PLAN EXAMINATION CONDITIONAL APPROVAL

PROJECT/SITE DESCRIPTION:
Maine Medical – Visitor’s Garage Extension

PROJECT ADDRESS:
22 Bramhall St – Portland, Maine

Review Type:	All Trades
Plans Date:	3/30/18
# of Sheets:	96
Project Area (sq. ft.):	82,201

2 NORTH ELEVATION  
 SCALE: 1/16" = 1'-0"

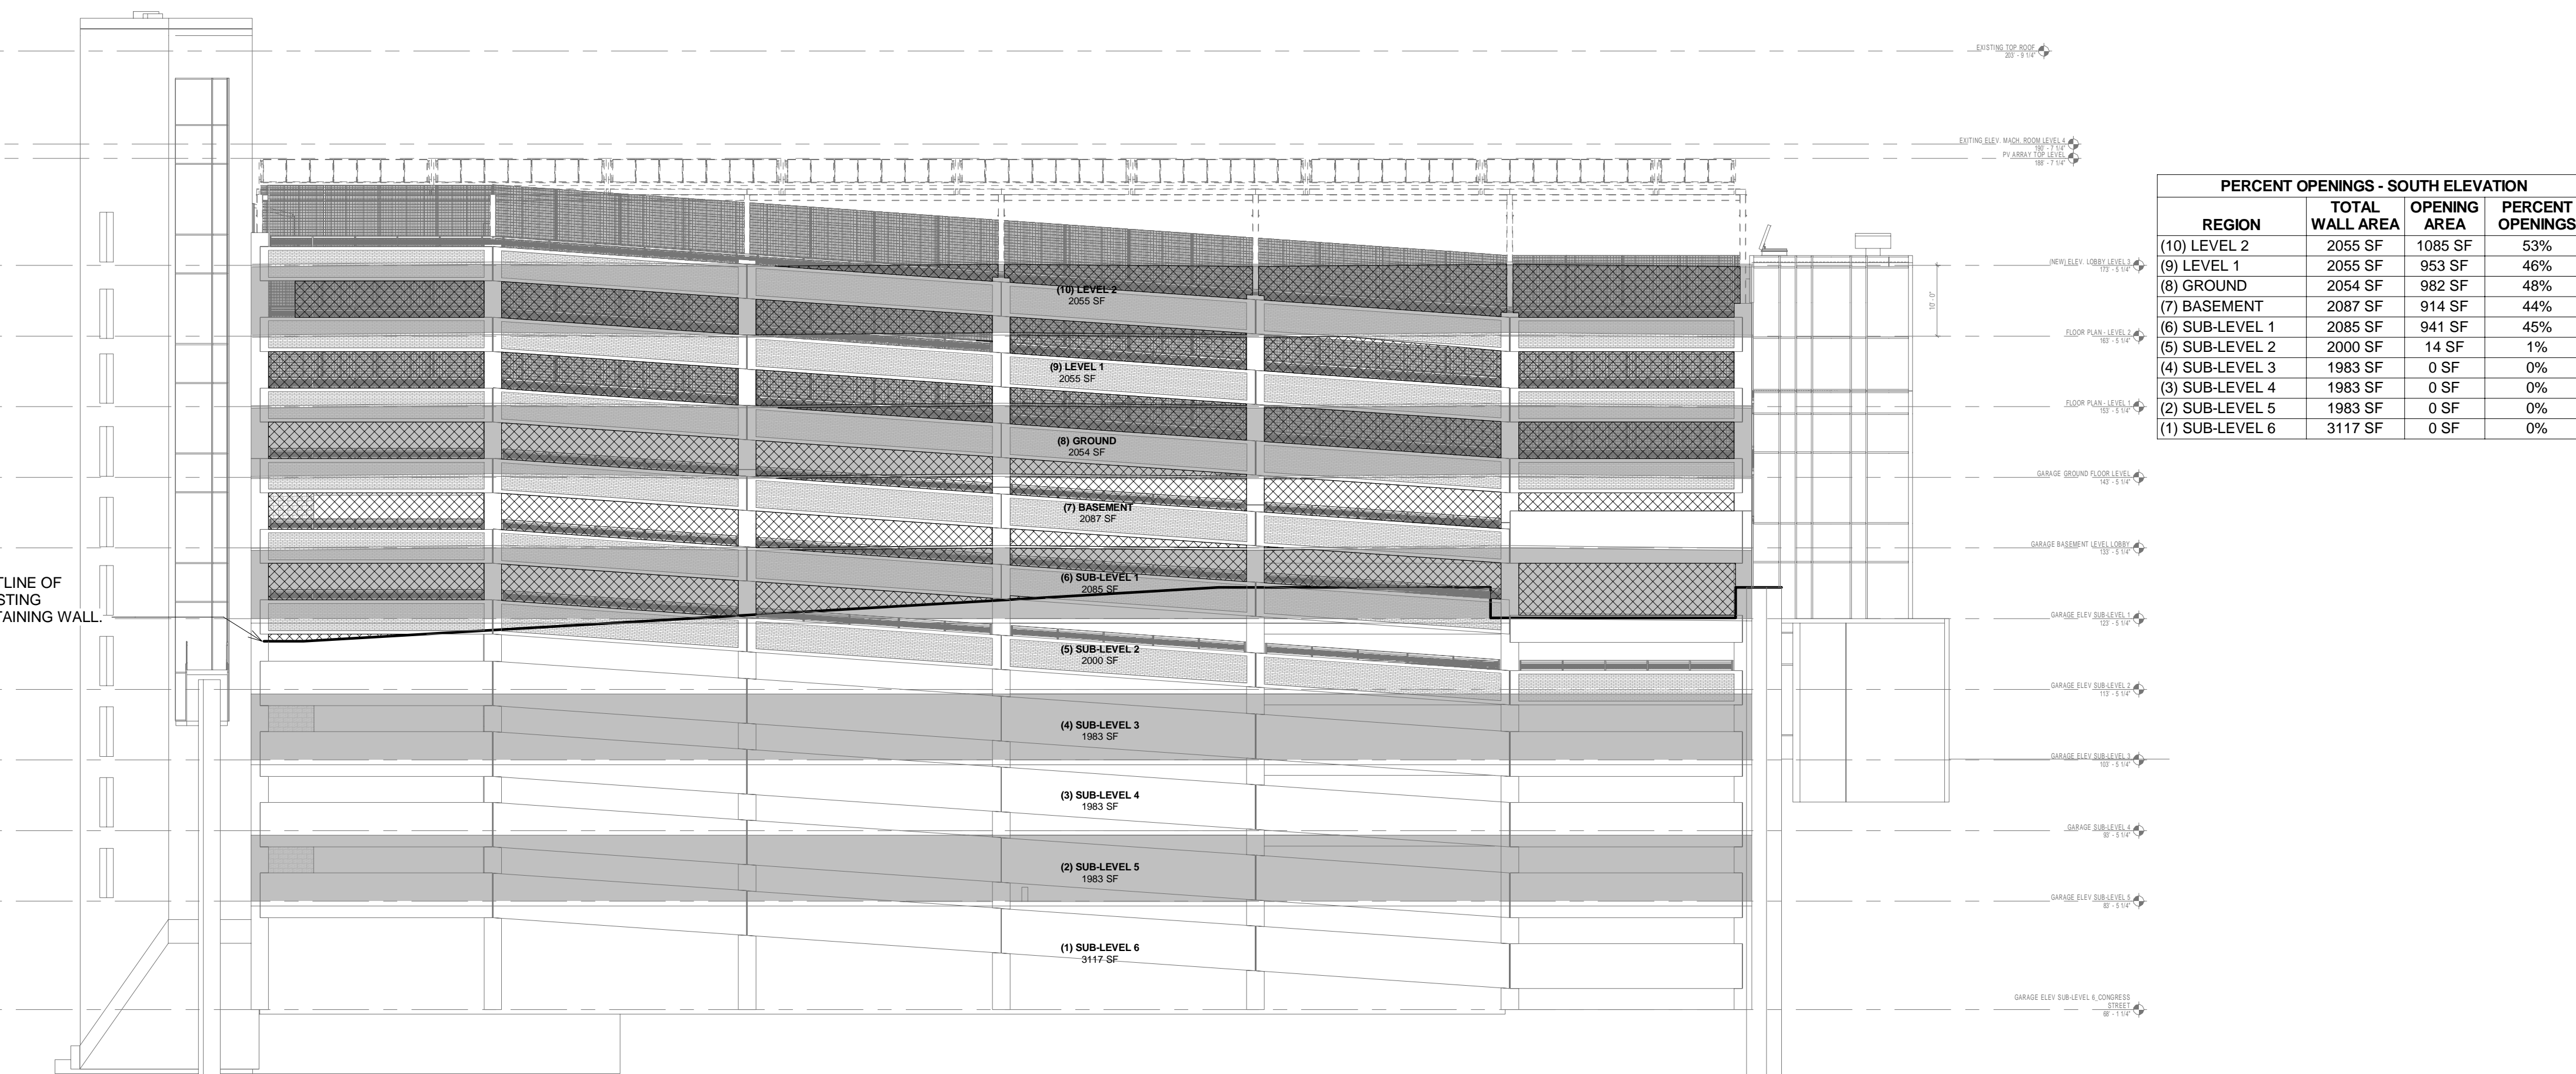
Plan Review Comments are based upon updated G02-01 Code Compliance Elevations sheets provided during review 3/27/18 demonstrating ventilation requirements meeting code requirements to allow for structure to be considered as an "Open Parking Structure".

1 FIRE PROTECTION RISER DIAGRAM
SCALE: NTS

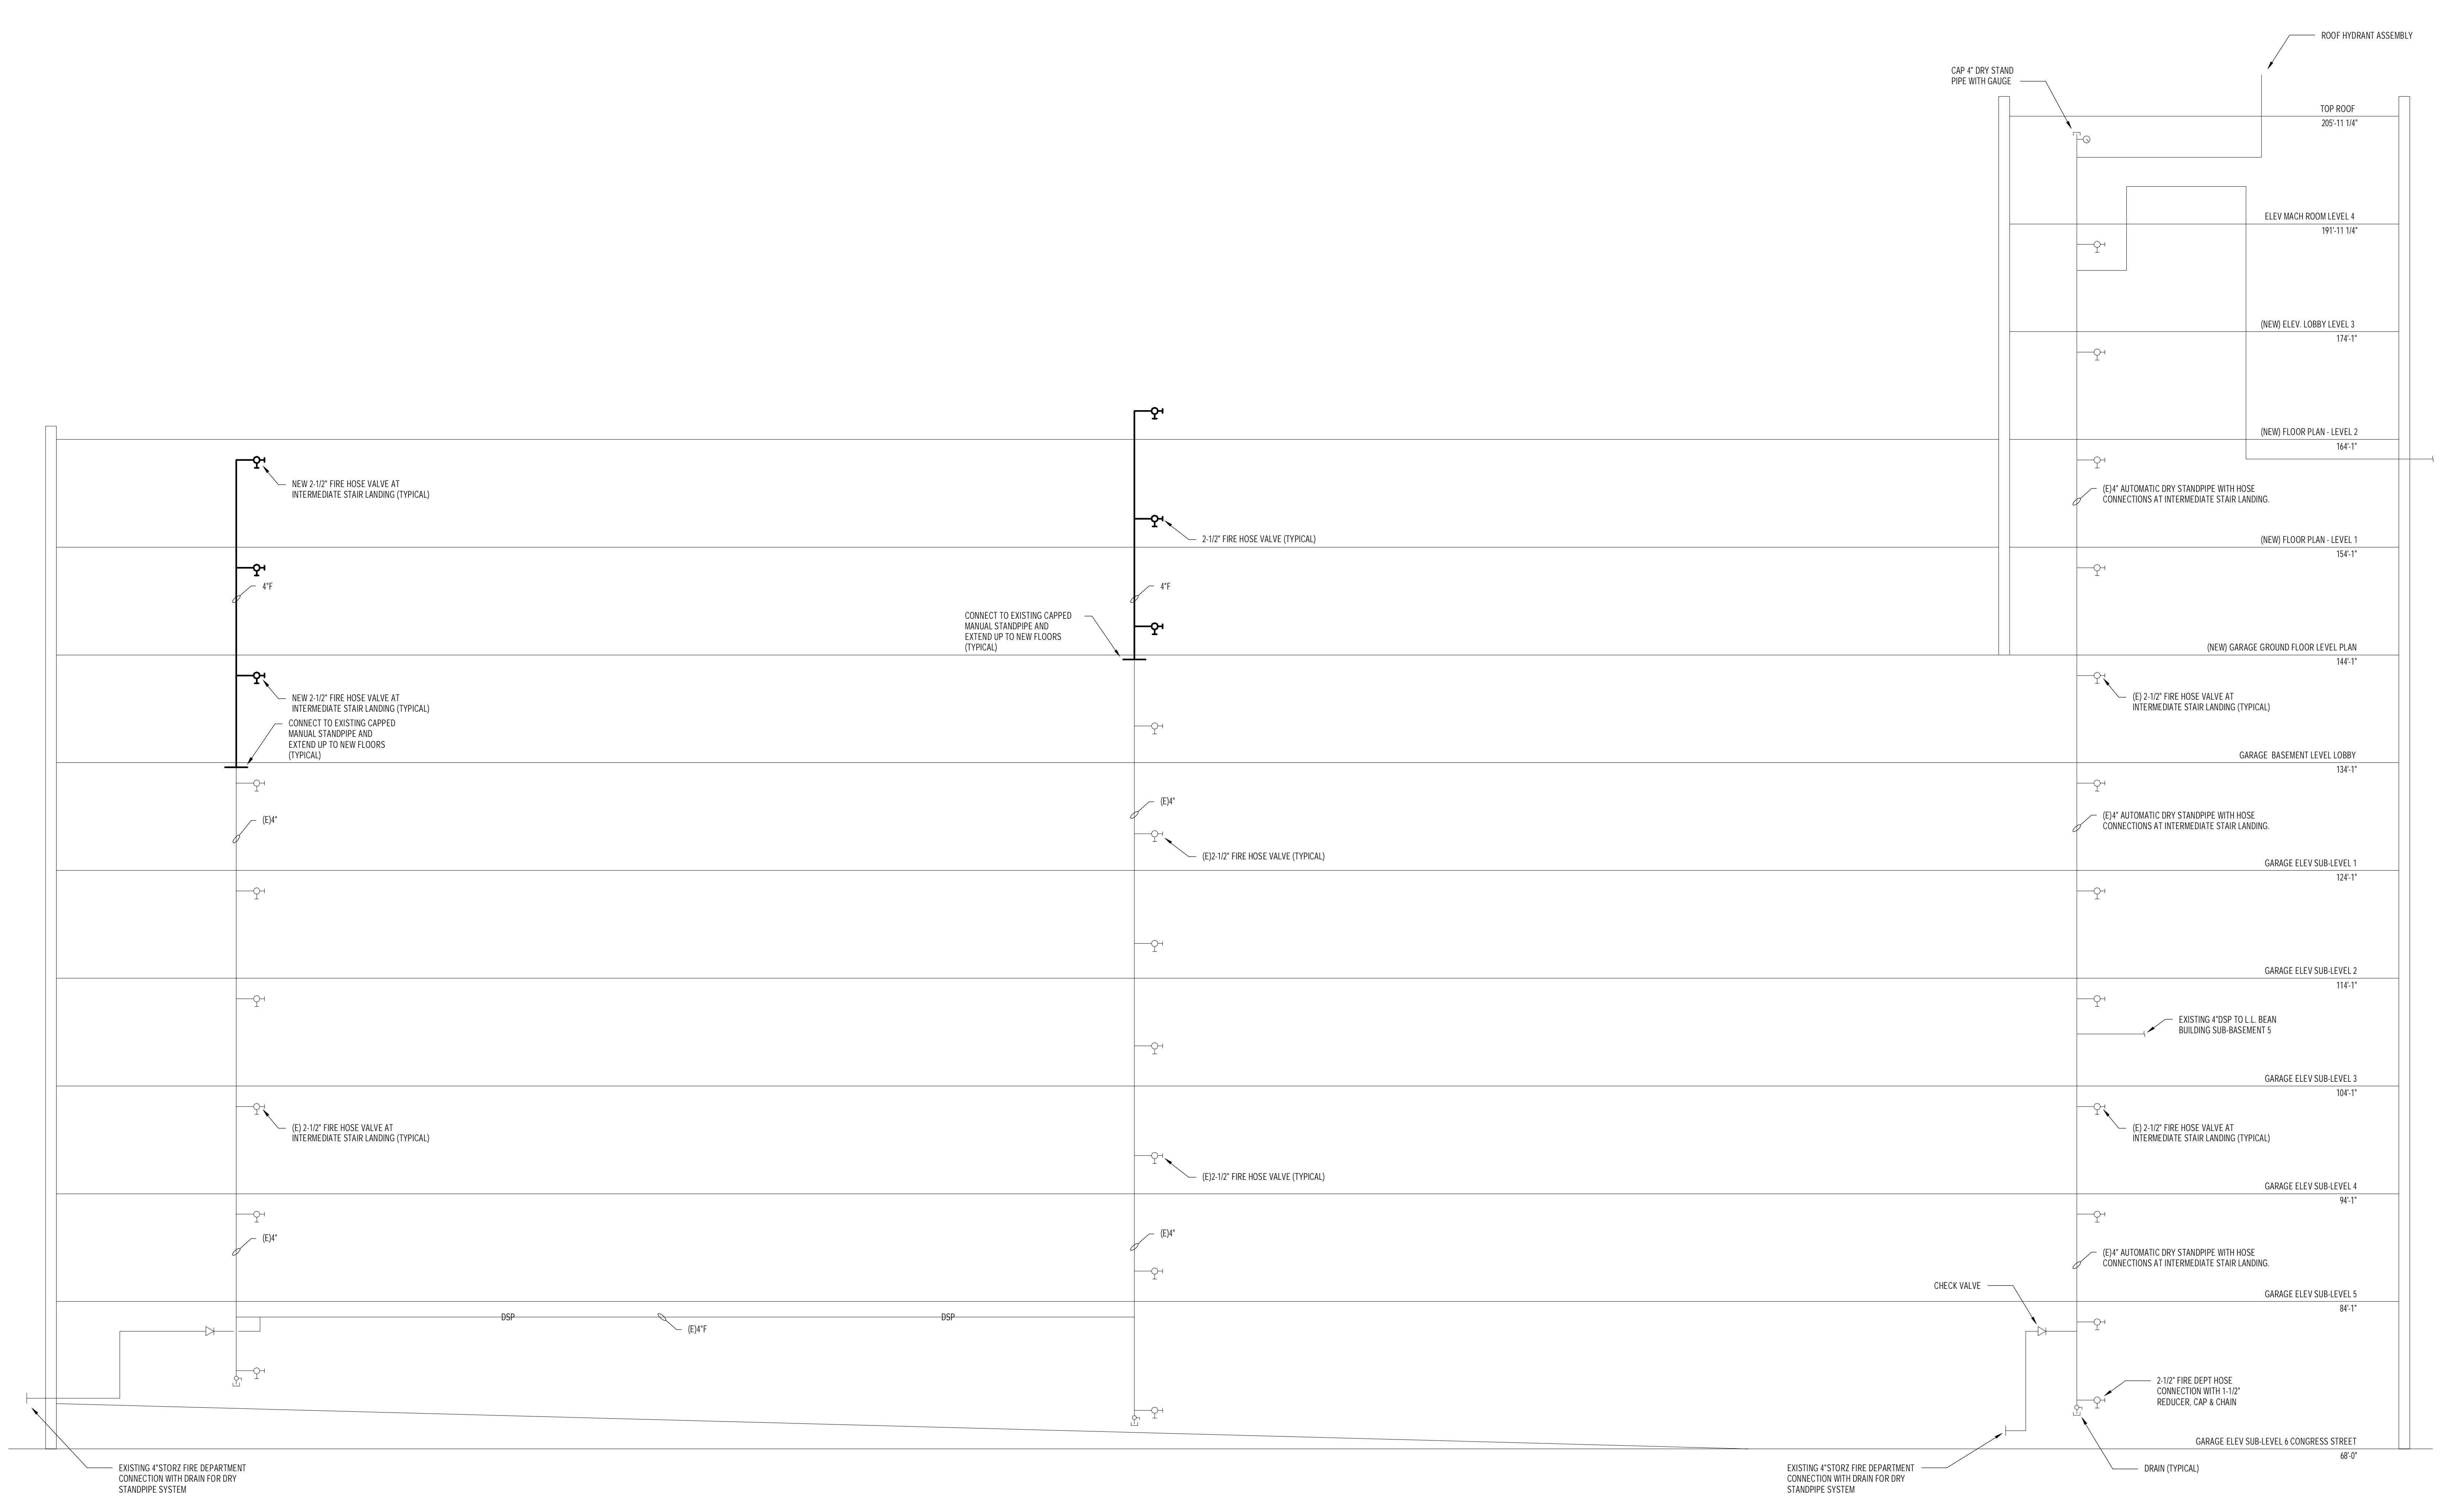
1. There is a discrepancy on the fire protection riser size. Sheet F00-10 & F10-10. Clarification needed.
2. Complete information regarding the fire protection system(s) shall be submitted to indicate conformance to applicable codes and regulations. The construction documents shall be approved prior to the start of system installation. Shop drawings shall contain all information as outlined in Chapter 9 of the Maine Building Code, NFPA 1 and NFPA 13. (IFC Figure 903.3)
3. Valves controlling water supplies shall be electronically supervised in accordance with the Maine Building Code (with exceptions) NOTE: Fire alarm plans have been submitted for review and do not indicate supervision. Please clarify.
